**Upgrades to John Palmer Public School (SSD-23330227)
Submissions Report**

ATTACHMENT 1 – KEY ISSUES

Title
LANDSCAPE PLAN

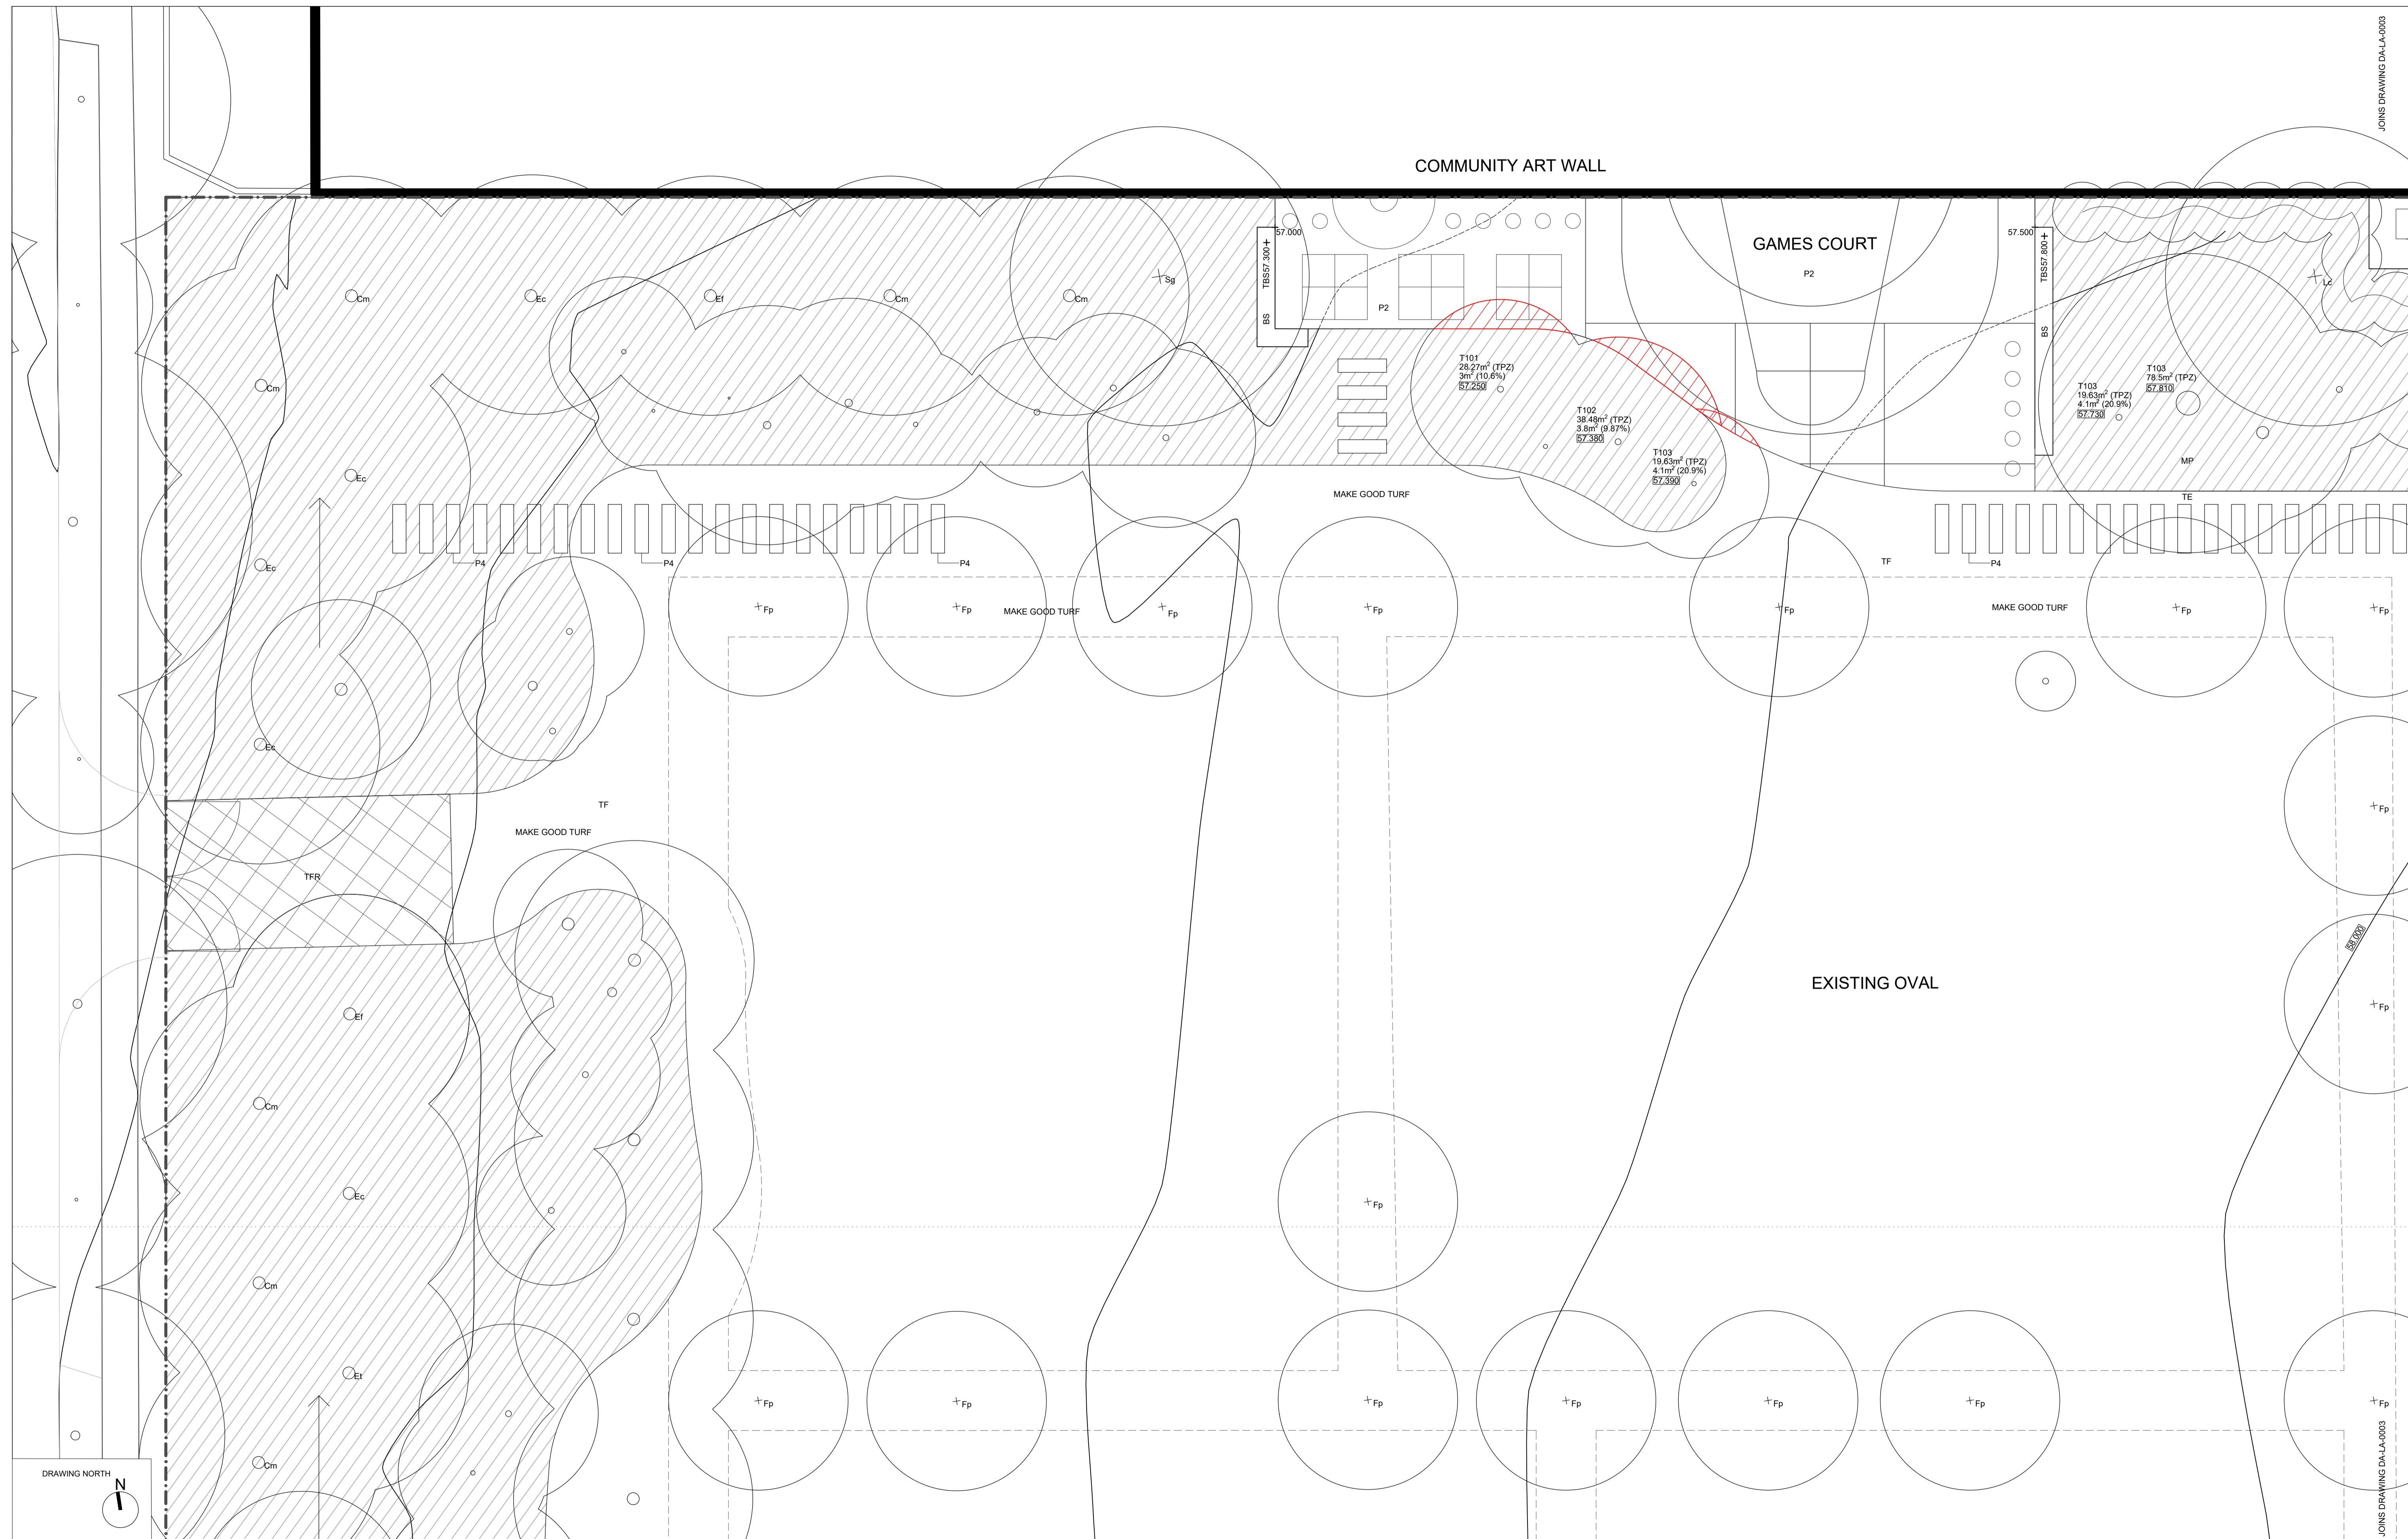
- Address the Government Architect NSW State Design Review Panel (SDRP) advice for the project, including advice relating to:
 - native landscaping and further opportunities to use endemic species that may attract native fauna to the school site and surrounding green spaces.
 - investigating further outdoor learning spaces, connected to proposed classrooms, that address Connecting with Country principles.
 - providing stronger visual connections between the school, Second Ponds Creek, and the green open space on the southern boundary of the site.

- Demonstrate consideration of the opportunity to increase the setback on Ponds Boulevard to protect and retain trees that are currently proposed for removal and which currently provide fauna habitat, landscape amenity and an increasing contribution towards mitigation of urban heat island effects on site and within the locality.
- Address the inconsistencies between the BDAR and EIS in relation to trees being removed and retained including, if required, an updated BDAR.
